**CITY OF PORTLAND, MAINE
DEVELOPMENT REVIEW APPLICATION
PLANNING DEPARTMENT PROCESSING FORM**

5/11/98
Application Date
Eastfield Rd #24
Project Name/Description

24 Eastfield Rd
Address of Proposed Site
194-C-058
Assessor's Reference: Chart-Block-Lot

**CITY OF PORTLAND, MAINE
SITE PLAN REVIEW (ADDENDUM)
CONDITIONS OF APPROVAL**

TITLE: SITE PLAN

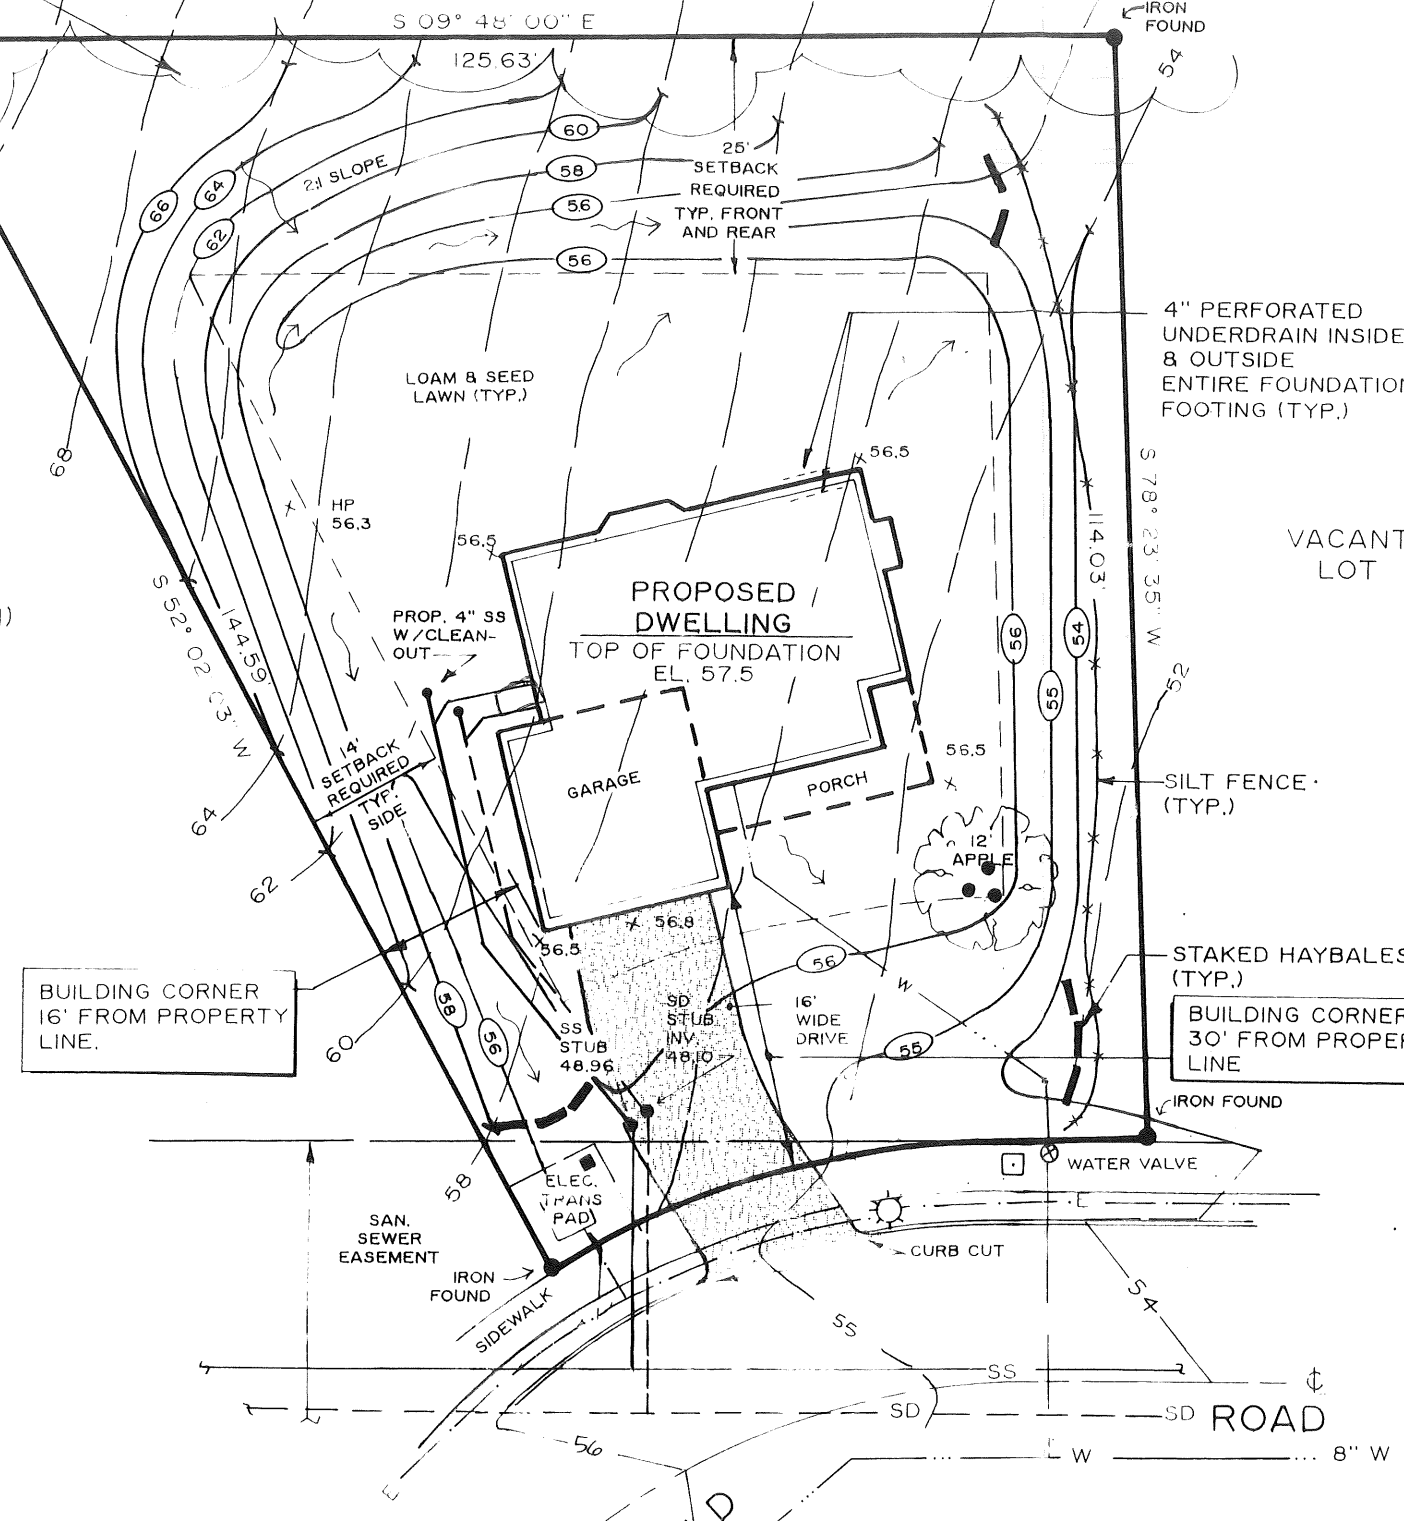
5. Show all utility connections: water, sanitary sewer, storm drain, electric, telephone, cable.
6. A sewer permit is required for your project. Please contact Carol Merritt at 874-8300, ext. 8828. The Wastewater and Drainage section of Public Works must be notified five (5) working days prior to sewer connection to schedule an inspector for your site.

- 9. The building contractor shall check the subdivision recording plat for pre-determined first floor elevation and establish the first floor elevation (FFE) and sill elevation (SE) to be set above the finish street/curb elevation to allow for positive drainage away from entire footprint of building.

- 10. The site contractor shall establish finish grades at the building foundation, bulkhead and basement windows to be in conformance with the first floor elevation (FFE) and sill elevation (SE) set by the building contractor to provide for positive drainage away from entire footprint of building.

- 11. A drainage plan shall be submitted to and approved by Development Review Coordinator showing first floor elevation (FEE), sill elevation (SE), finish street/curb elevation, lot grading, existing and proposed contours, drainage patterns and paths, drainage swales, grades at or near abutting property lines, erosion control devices and locations and outlets for the drainage from the property.

- 13. ERODED SOIL SHALL BE CONTAINED ON-SITE
A CAUSHON GRADE CONSTRUCTION ENTRANCE
SHALL BE INSTALLED.
